September 26, 2008

Please note the changes made below regarding water volume available under the domestic well use exemption for the DW Farms Short Plat (SP-08-00021). In order to meet the requirements set forth by Kittitas County Public Health's Environmental Health Division and Kittitas County Code Chapter 13, the following items must be submitted:

**DW FARMS SHORT PLAT**  
LOCATED IN SECTION 32, TOWNSHIP 18 NORTH, RANGE 20 EAST, W.M.  
KITTITAS COUNTY, WASHINGTON  
SP-

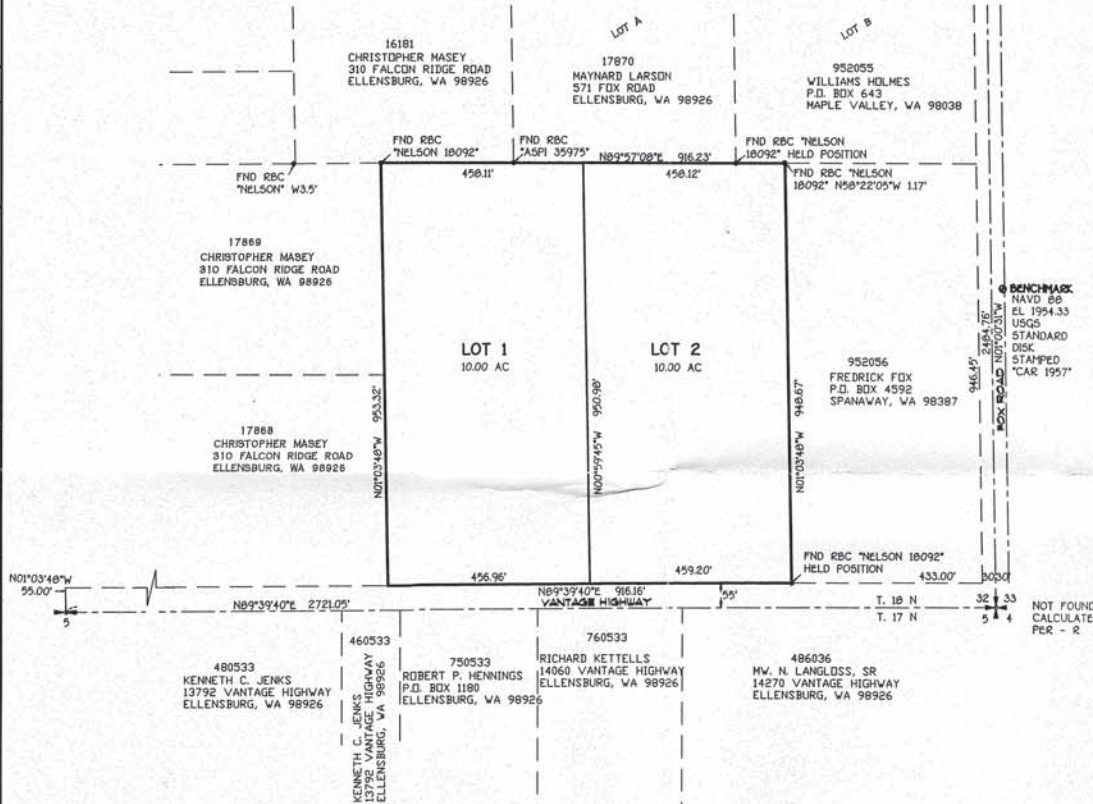
- Soil logs for each lot where installation of a septic system is intended;
- Well log for the existing well on the property, or a hydro geological report indicating water is available;
- *The following plat notes shall be included on the final mylar:*
 1. "The approval of this division of land includes no guarantee that there is a legal right to withdraw groundwater within the land division. The approval of this division of land provides no guarantee that use of water under the ground water exemption (RCW 90.44.050) for this plat or any portion thereof will not be subject to curtailment by the Department of Ecology or a court of law."
 2. "The DW Farms Short Plat (SP-08-00021) currently has a total of 5,000 gallons of water per day for all domestic and irrigation uses from the exemption. Each newly developed parcel will receive 2500 gallons per day".

Note: if distribution of the available water between parcels is different than listed above, specify the quantity of water in gallons per day by parcel on the final mylar.

3. Kittitas County will require all new development county-wide to include water meters for each individual residential connection. Kittitas County Public Health's Environmental Health Program will choose the meter brand and
